## **SDNP/24/00399/DCOND**

Application Number: SDNP/24/00399/DCOND

Address: Manor House High Street Droxford Hampshire SO32 3PA

Proposal: discharge of condition 3 of planning application SDNP/22/01867/HOUS

PROPOSED ENTRANCE GATE: JOINERY DETAIL 1:10

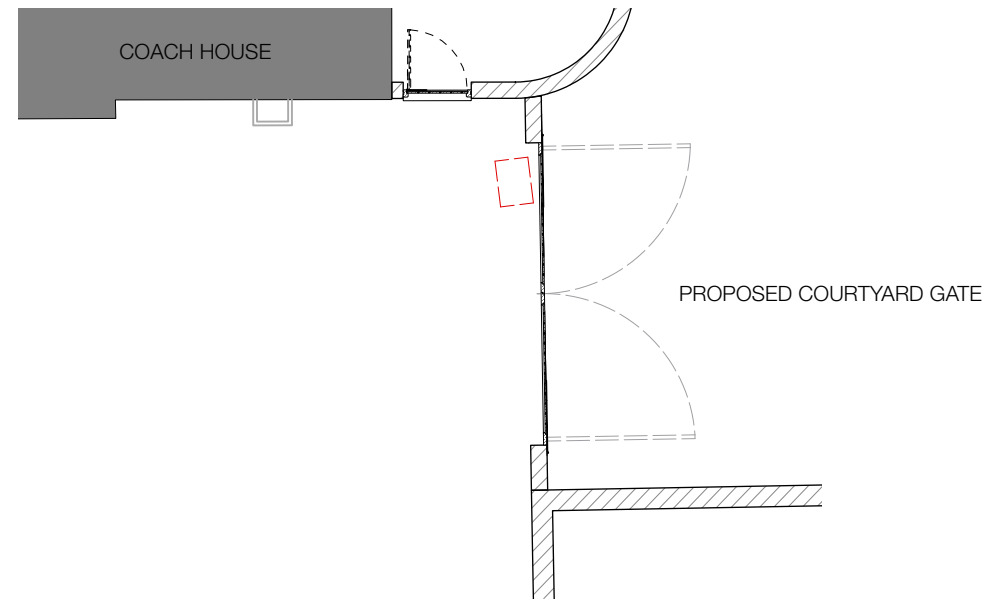
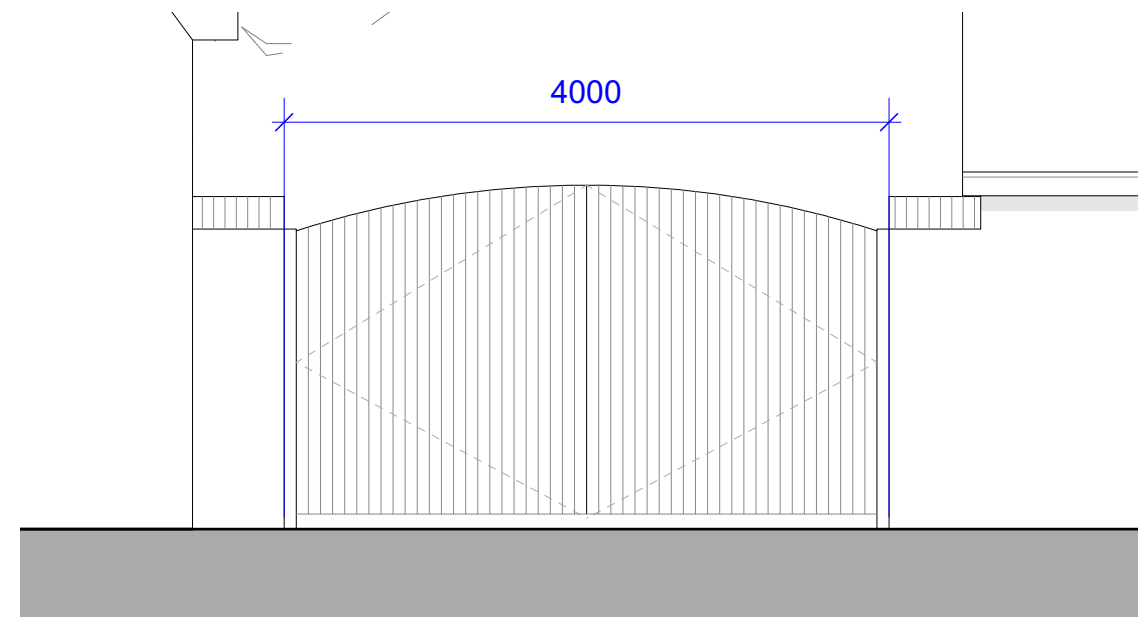
Ledge and brace door to car port acceptable. Garden gate near the coach house acceptable. Is the gate in the listed wall intended to be similar? No details submitted.
